LOCAL IMPACT REPORT

Thanet Windfarm Extension DCO (PINS Reference EN010084)

Produced by Kent County Council (KCC)

Temporary Stopping Up of
Public Right of Way -
Sheet 1 of 2

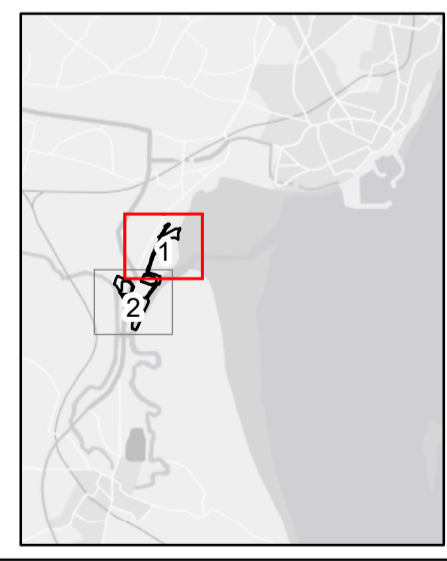
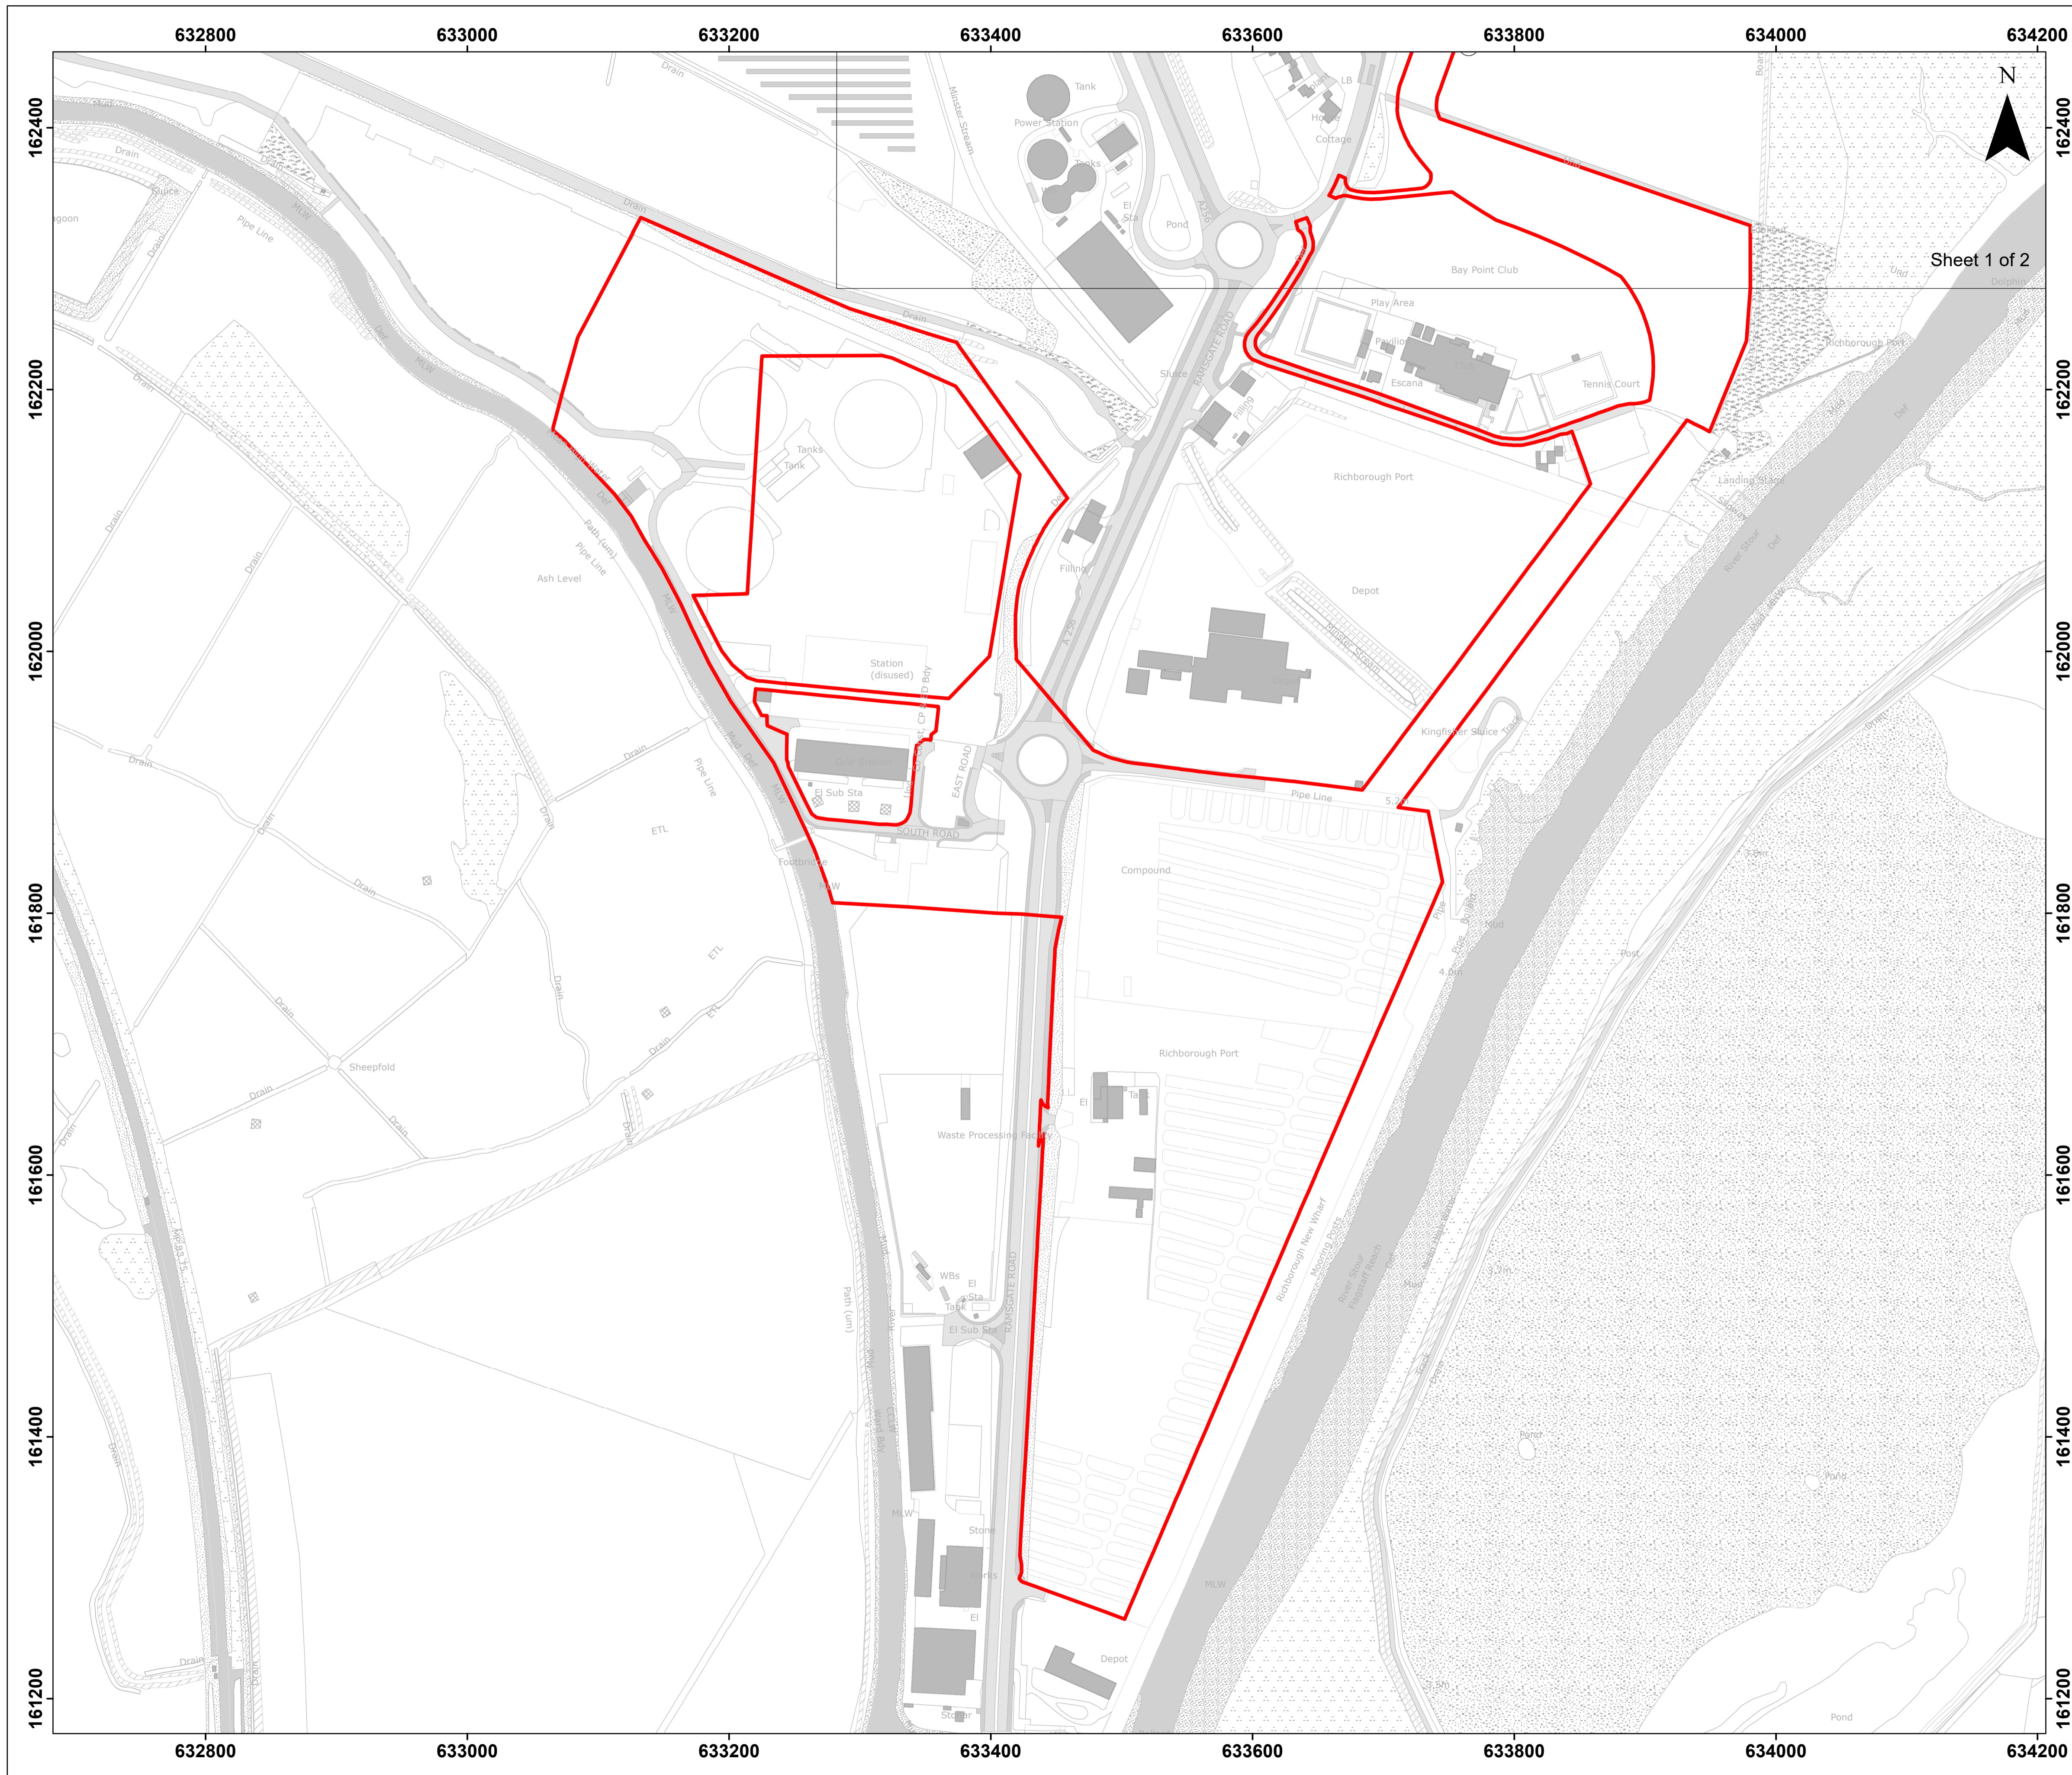
- 2.5.1 As stated in the Access Management Strategy, the England Coast Path and Thanet Coast Path will be obstructed for a number of months by the construction of the landfill site and transition pit.

- 2.5.2 Within Option 3 (open trenching), the England Coast Path (ECP) will be affected, if not temporarily closed, due to the planned works. The applicant should work closely with relevant KCC PRoW officer to ensure the path is adequately re-routed to allow access across the park whilst the works are undertaken. The OLEMP states that, 'where possible soils will be carefully restored' where the ECP is disturbed. This will need to be looked at in detail with KCC officers to agree the reinstatement of the soil and a method of colonisation of vegetation.

Figure 1

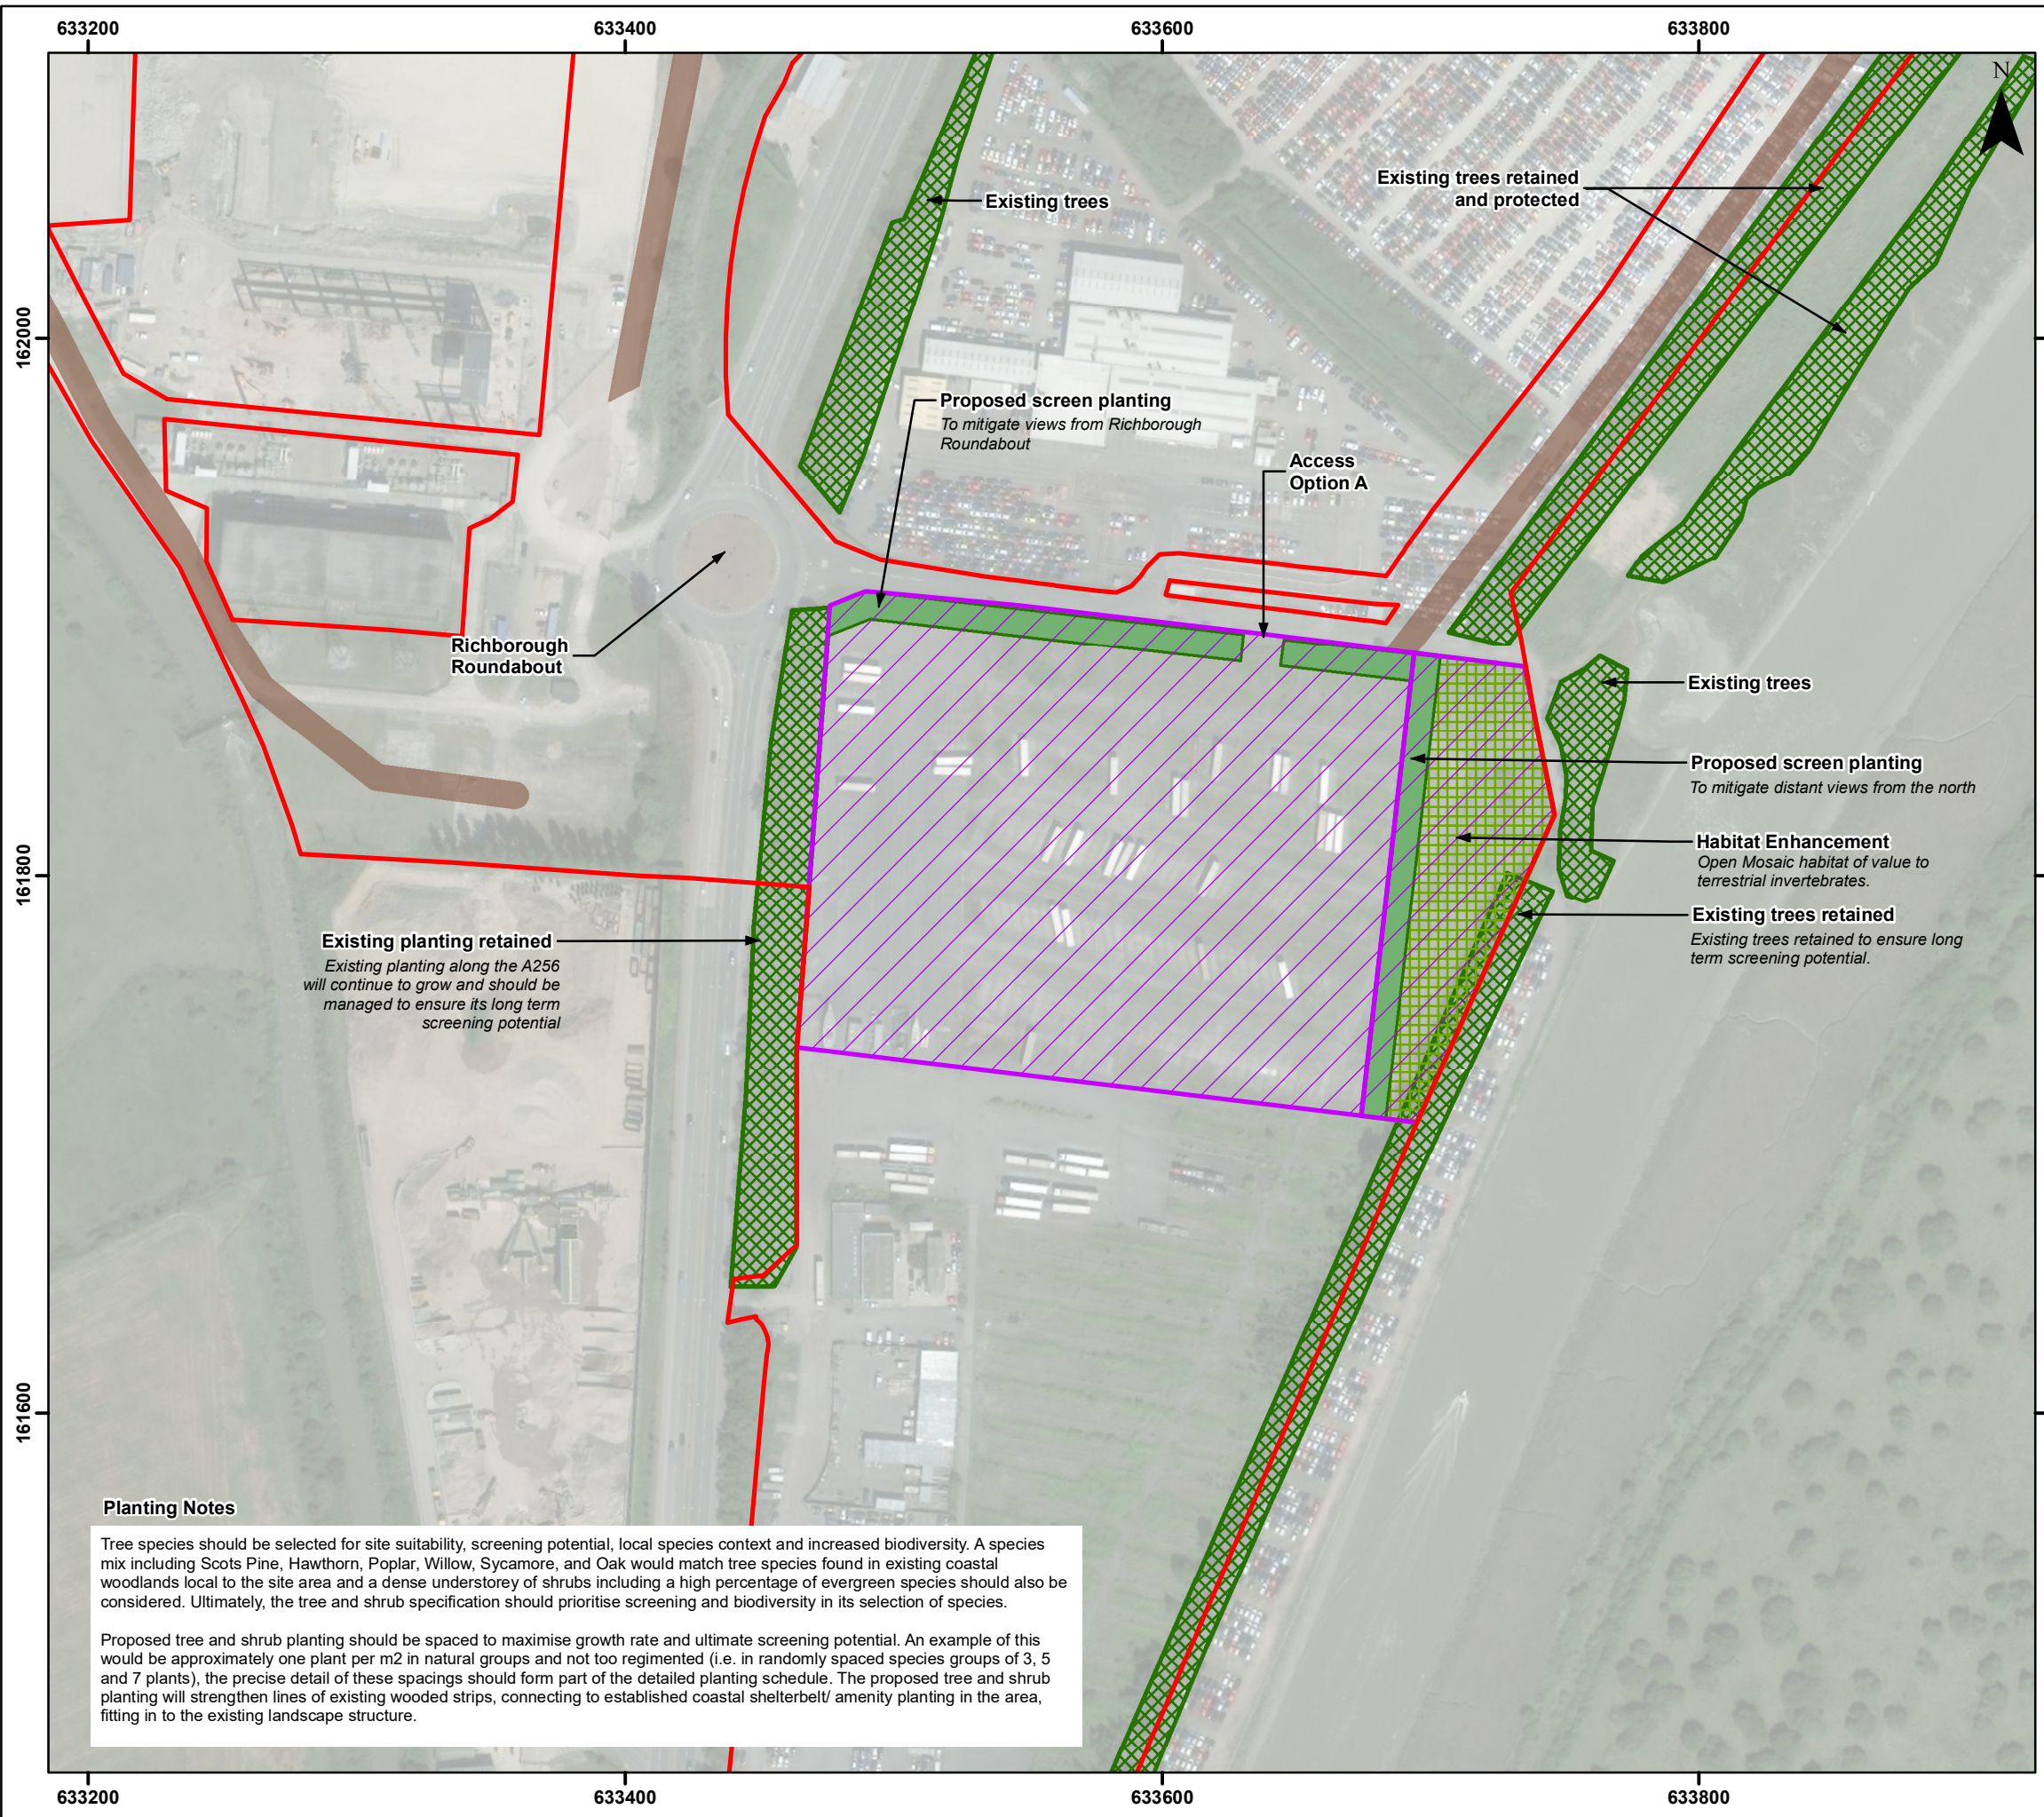
2.1.7 Within Option 1 (HDD), it is stated in the Outline Landscape and Ecological Mitigation Plan (OLEMP) that a larger work area will be required (around 50x60m). It is unlikely that this will be possible in the area outlined as the 'works area', as this space is not available on site, due to the proximity of the main road, the Sustrans route and the NEMO bund. This leaves little space to develop a work area for the construction phase.
